Our Ref: R/2023/9
File No: 2023/154349
Your Ref: SSD-32766230

**Advice on Environmental Impact Statement – 35-75 Harrington Street, The Rocks
– SSD-32766230**

Thank you for your correspondence dated 10 March 2023 inviting the City of Sydney (the City) to comment on the Environmental Impact Statement (EIS) and supporting documents submitted for the development proposed at 35-75 Harrington Street, The Rocks.

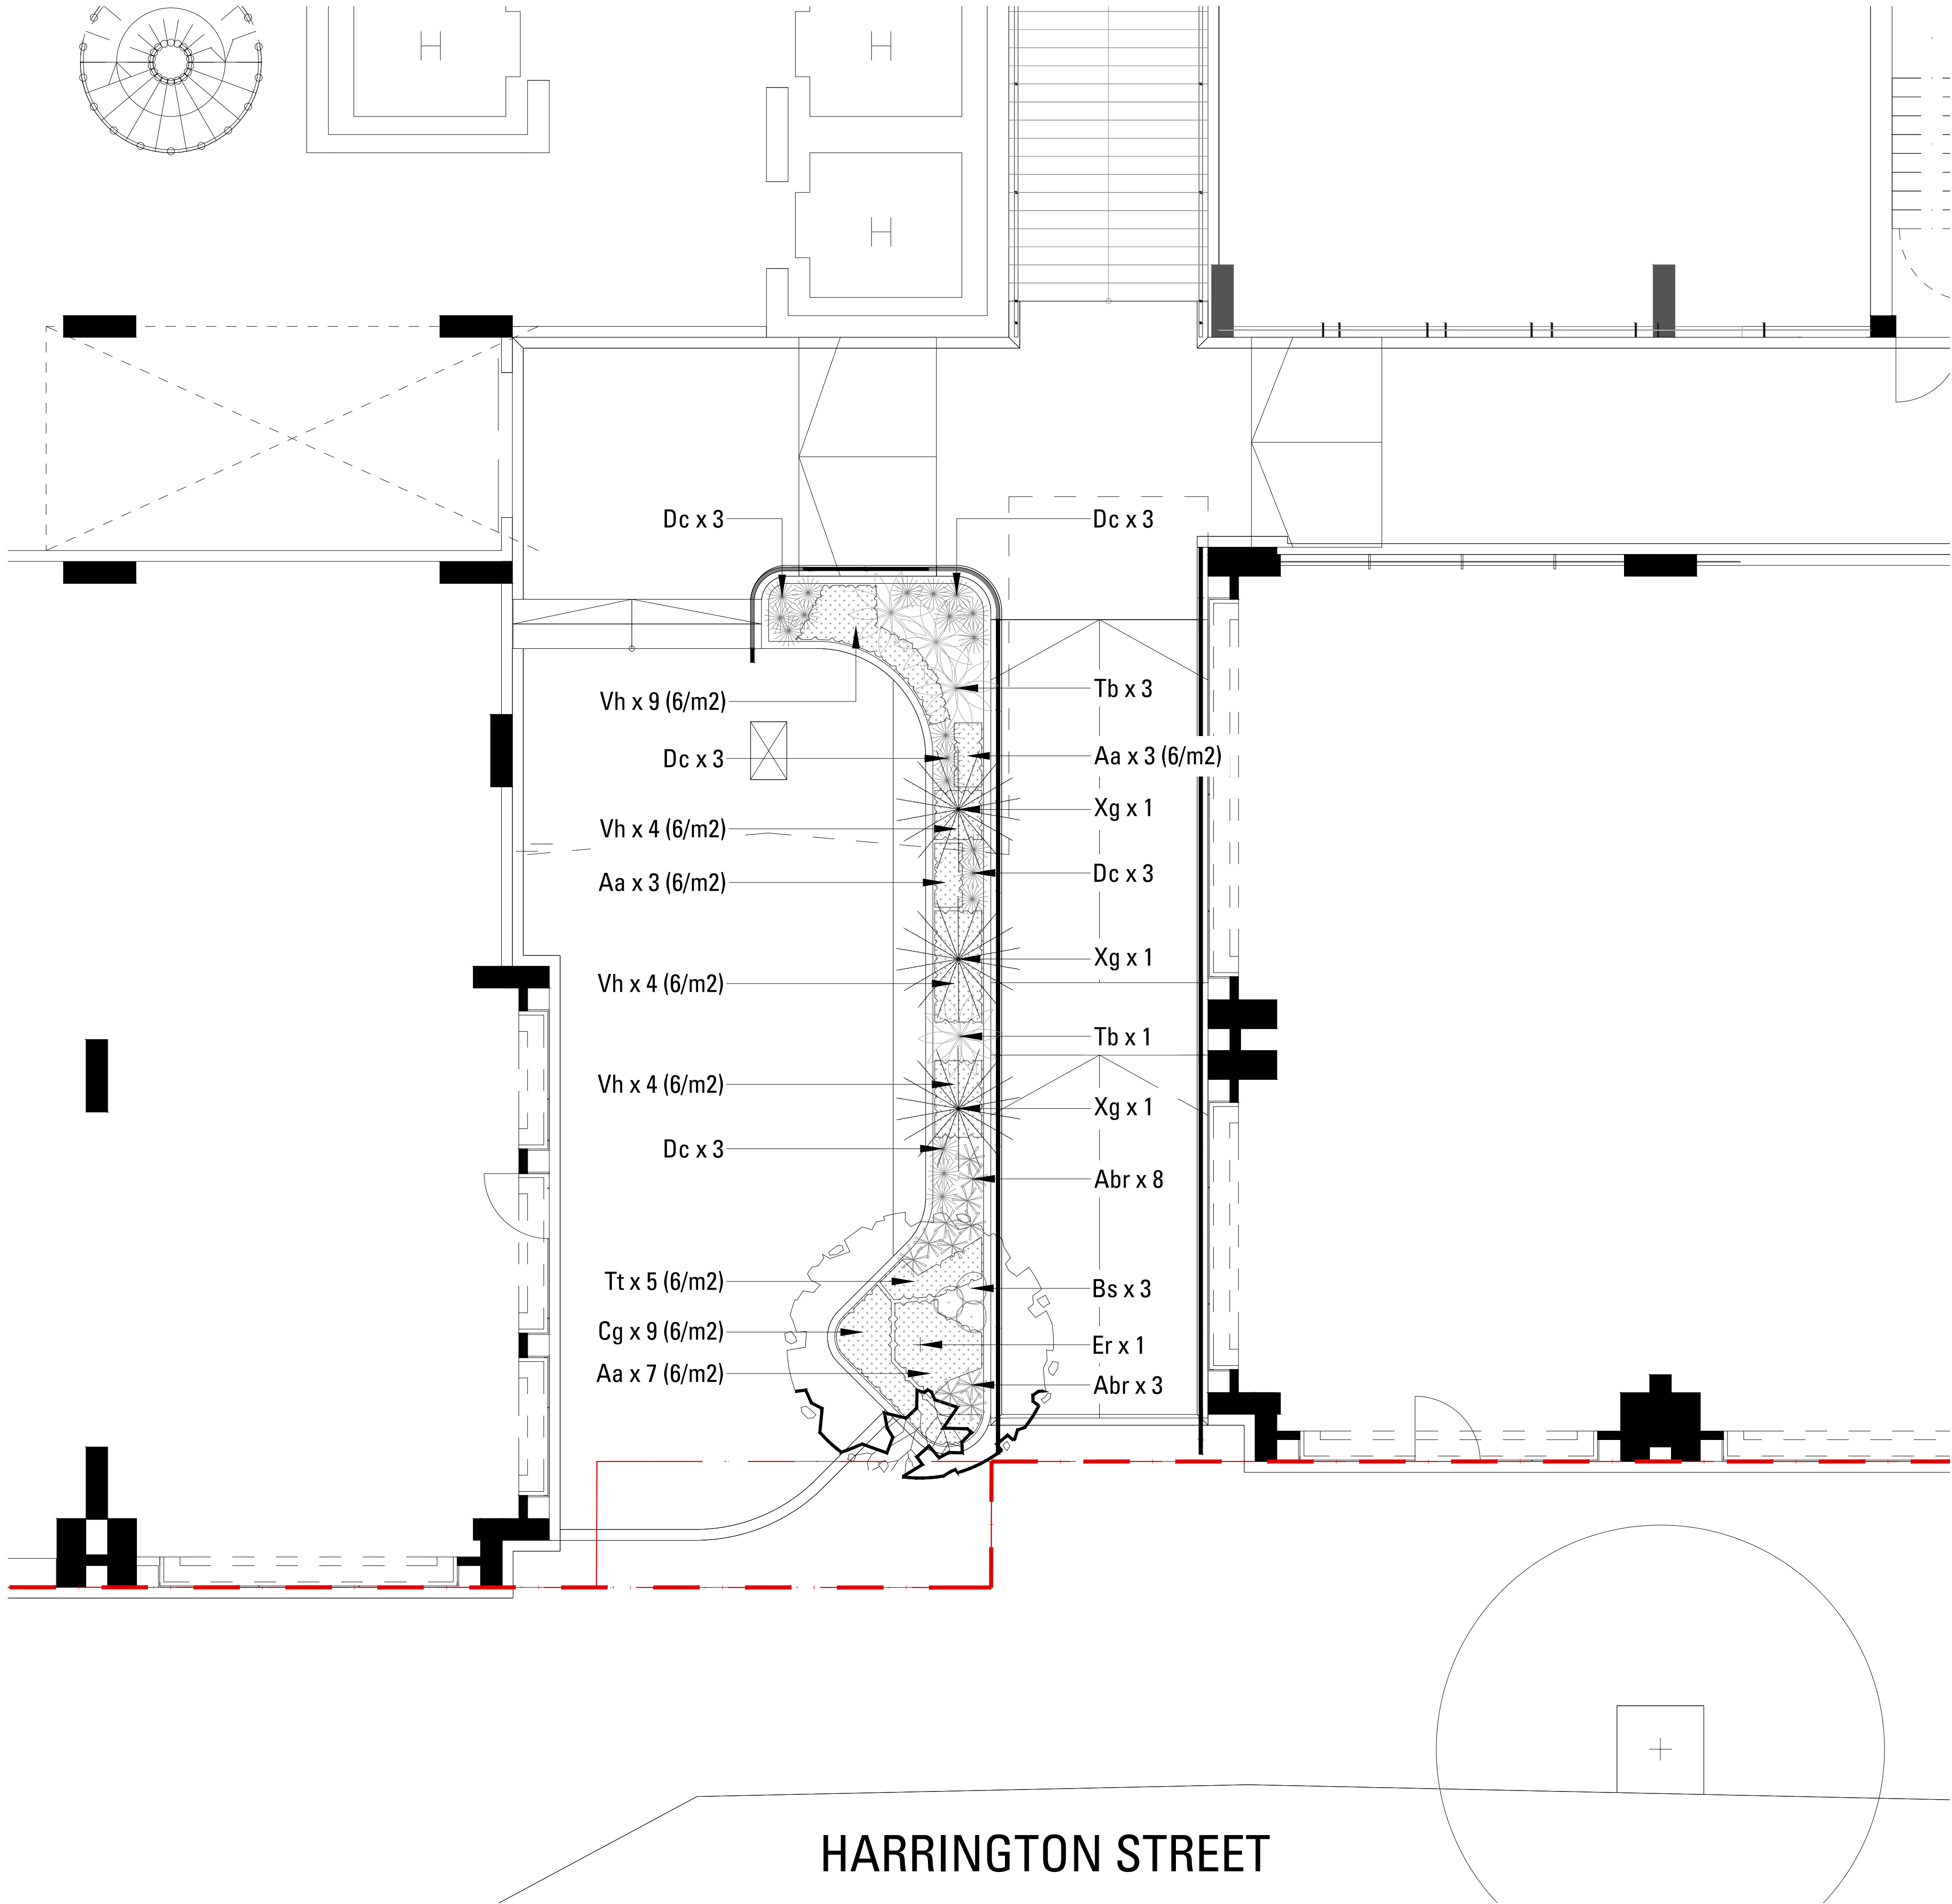
The Level 6 Architectural plans indicates areas of planting to the south of plant areas (Figure 3 below) that are not included in the landscape plans.

While the landscape plan include planting on the western edge of Level 6 that are not shown on the architect plan.

Figure 4: Landscape Level 6 plan (L404 [A]) with landscape areas shown in magenta that are not included on architect plans

- The Level 6 Rooftop terrace includes hotel amenities and swimming pool, outdoor bar and lounge area. The spaces are edged by narrow perimeter planters ranging in width from 300 to 680mm wide. There is a lack of clarity for the terrace levels and whether the planters are BCA compliant forming the balustrade to prevent people stepping up into planter and falling over the building edge.

- The proposed planting palette comprises a native species that are sun loving. These plants will be shaded by the mature Plane street trees in warmer months. The planting design should be properly reviewed to ensure final species selection meets the site microclimate and available access to sunlight.

- There is a pool on the eastern corner of the roof terrace accessed by stairs. No pool fence and gates are shown and whether this sits on the outside edge of the perimeter planting.

- The landscape plans must be co-ordinated with the architect and updated to show all landscaping proposed, include levels (RL, SSL, TW), location of balustrades, pool fencing and all features. Include two sections through the roof terrace (red lines) to demonstrate the design, levels, balustrades/fencing

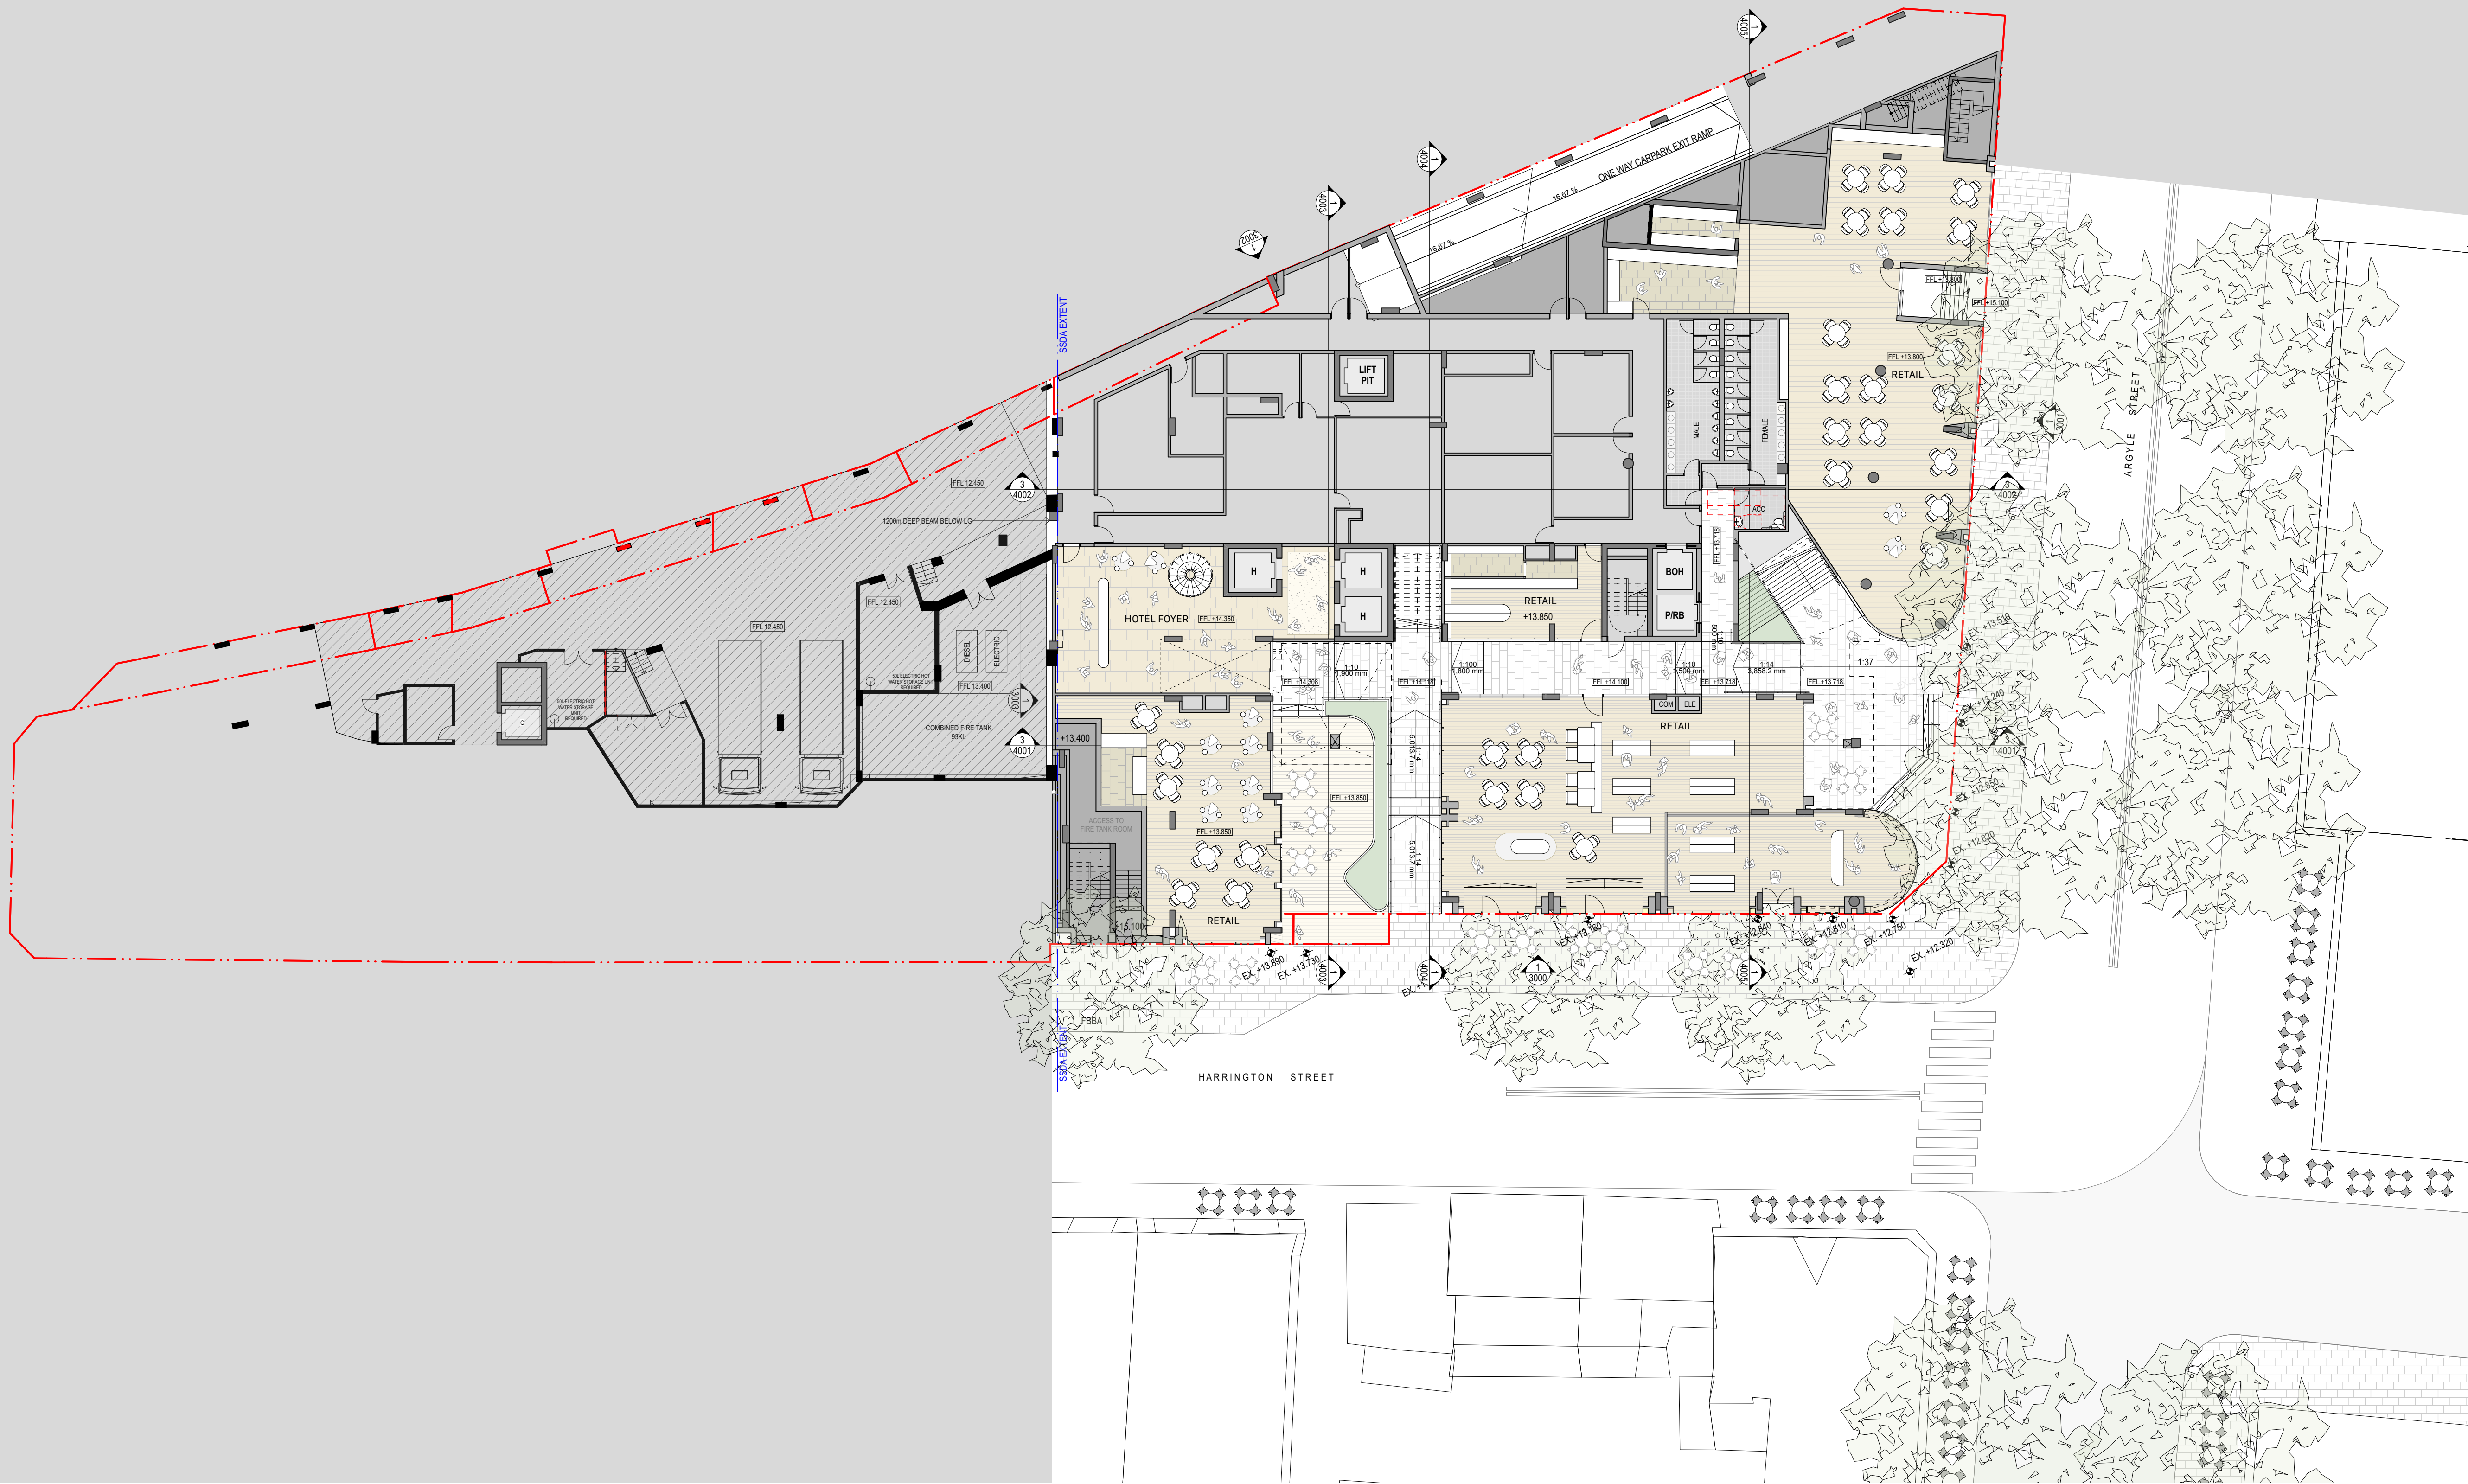
- Level 1 Architectural Plans include perimeter planters to 11 eastern hotel terraces that are not included in the landscape drawings. The Roof Plan (DA-2007[01]) indicates an inaccessible green roof in the central void that is not shown on the Architectural level 1 or Landscape plans (refer to Figure 1 below).

Figure 1: Architectural Level 1 plan (DA-2000 [01]) with landscape areas shown in magenta
